3/2023/1011

Proposed conversion to five flats at 41-43 Wellgate.

PROPOSED GROUND FLOOR PLAN - 108m²
1:100 @ A3

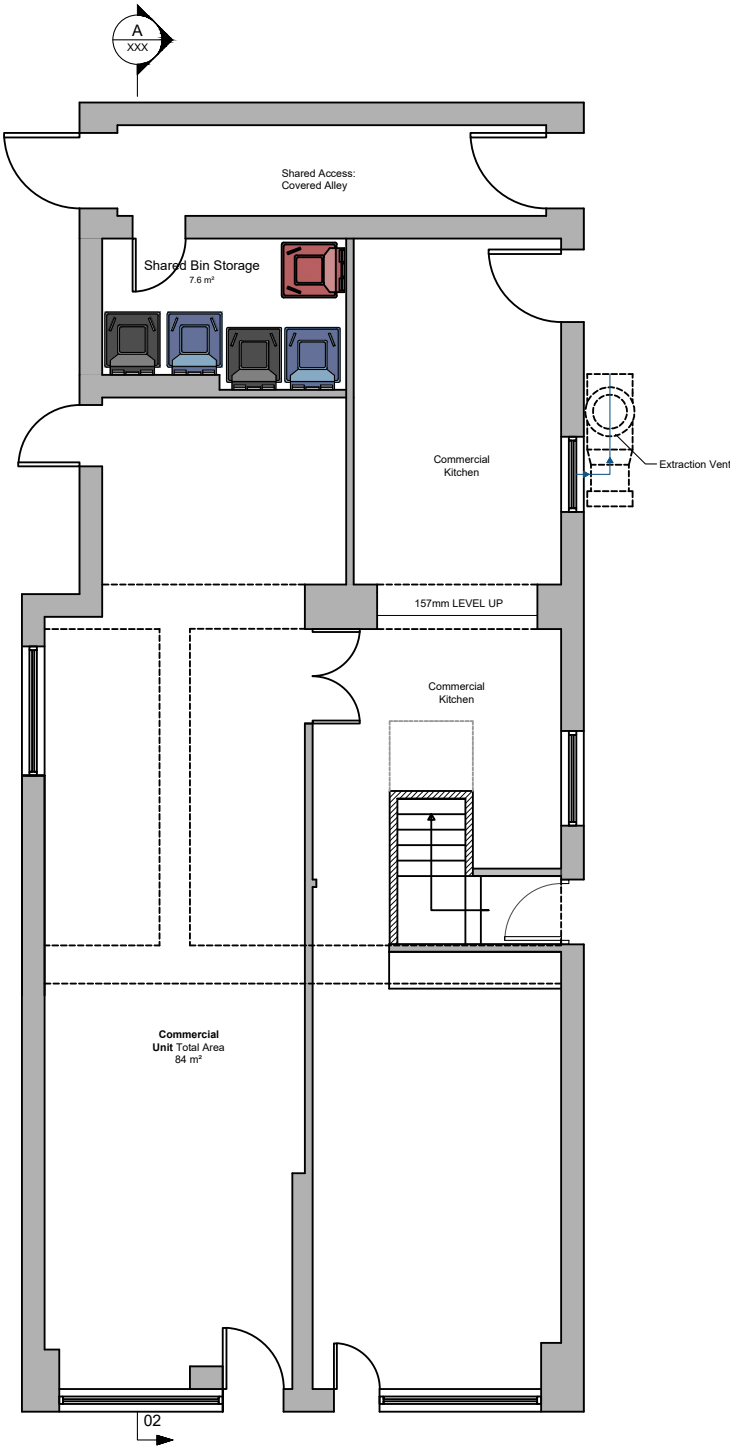
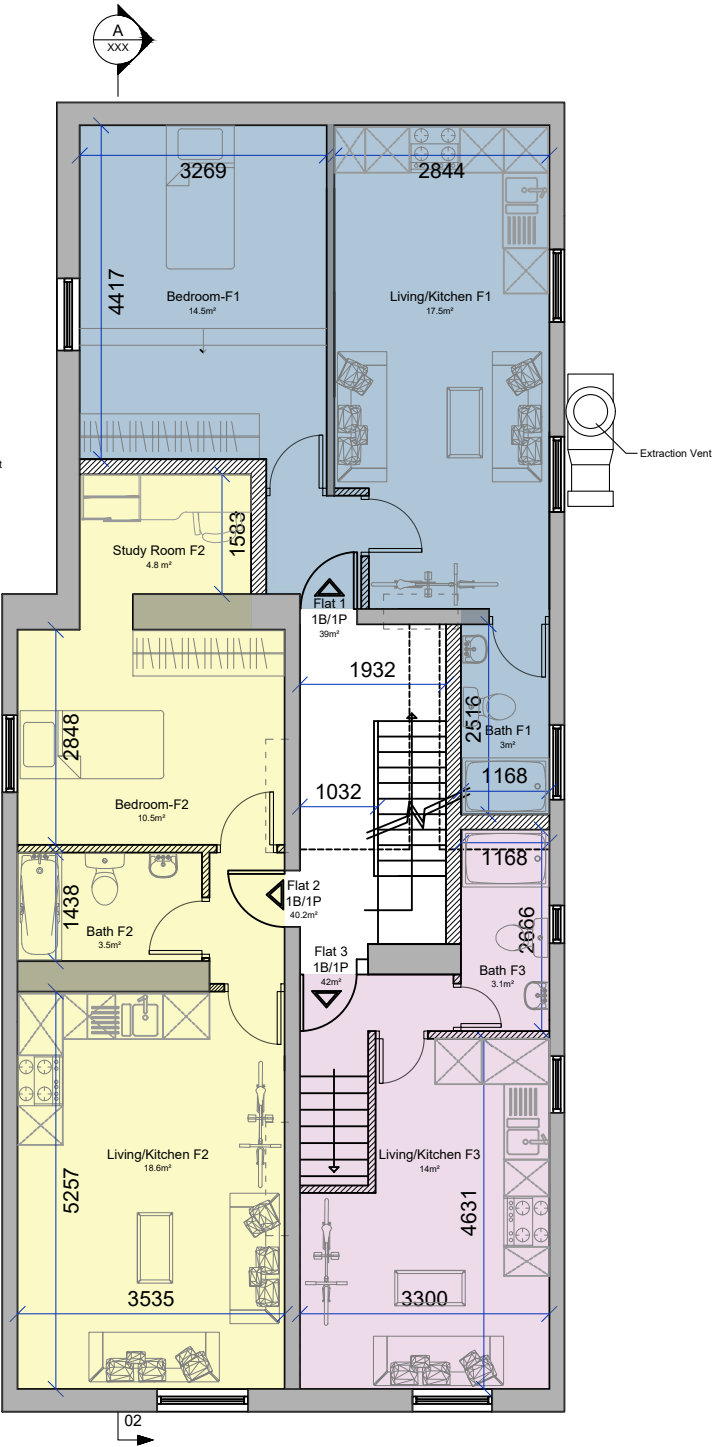
Furthermore, refuse disposal proposals appear far from adequate for a property with five residences and a takeaway food outlet and access to the refuse bin area appears to be difficult and inconvenient.
